CITY OF PORTLAND BUILDING PERMIT

PERMIT ID: 2013-00535

has permission to **Add awning - 2.5' tall by 12' wide on rear of building (no signage) & replace 3 building signs - two signs, each one 32.25" x 92", one facing Brighton & one facing Stevens & one on front, 42" x 114"**

City of Portland, Maine - Building or Use Permit

The Crooked Mile
Coffee house & Cafe

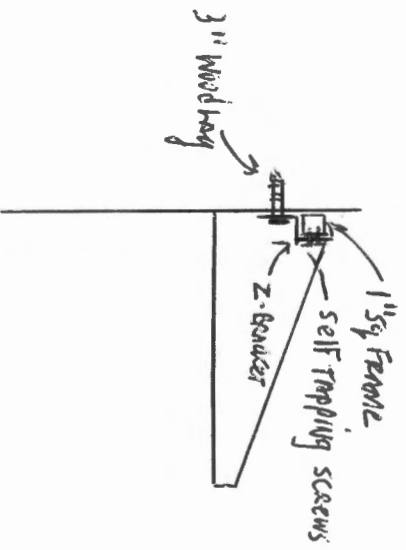
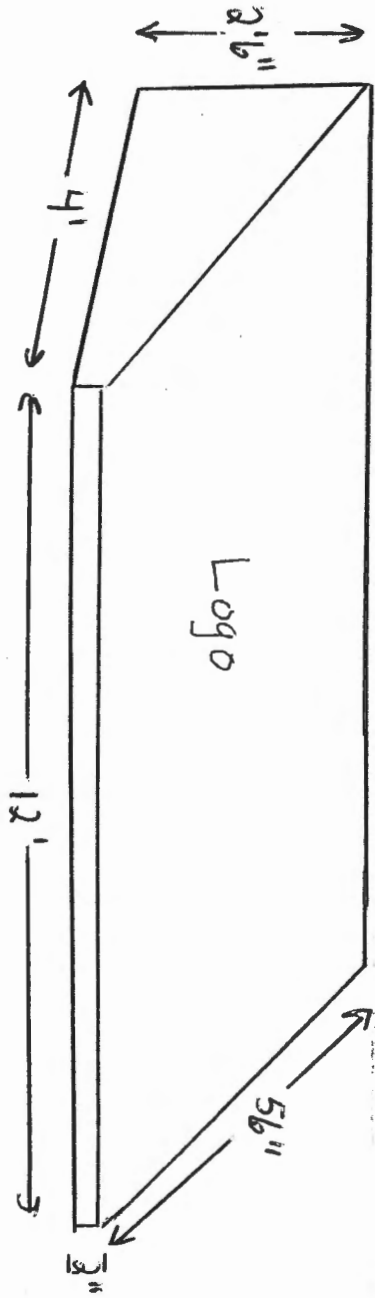
1) This permit is being issued with the condition that the awning will not have any signage or graphics on it.

Customer Name: The Crooked Mile  
 Job Description: MDO Building Sign  
 Sales Rep: JK  
 Drawn By: JK  
 Job Number: 1229  
 Revision Version #: 8  
 Date: 1.24.2013  
 File Location: Crooked Mile/1229

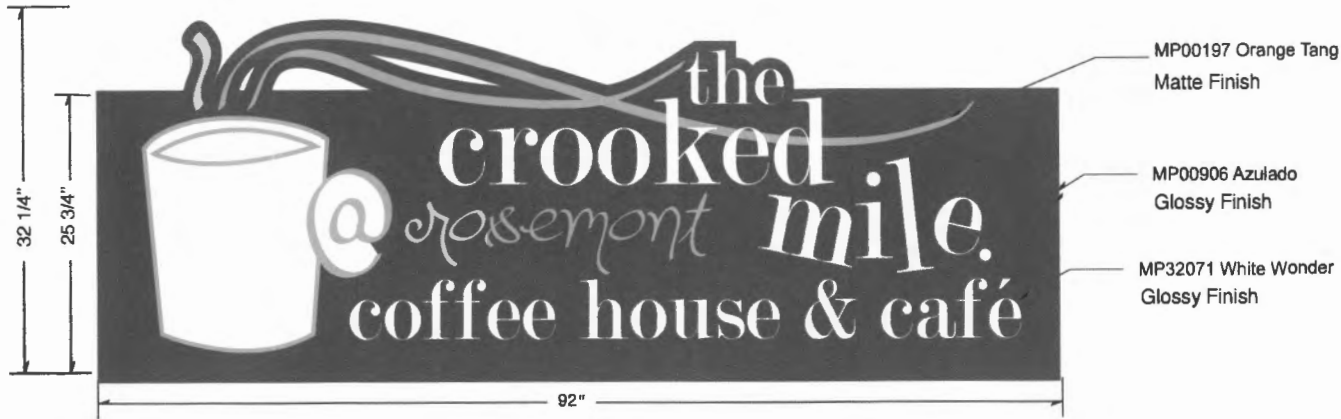
Note: Use is legally nonconforming, so the signs are legally nonconforming. Can't increase the square footage of the existing signs or the number. According to permit #980325: **Ok to Issue:**

Existing sign on Brighton - 31" x 124" = 26.7 sf
 Proposed sign on Brighton is 32.25" x 92" = 20.6 sf
 Existing sign on Stevens is 36" x 198" = 49.5 sf
 Proposed sign on Stevens is 32.25" x 92" = 20.6sf
 Existing sign on front is 30.5" x 192" = 40.7 sf
 Proposed sign on front is 42" x 114" = 33.25 sf
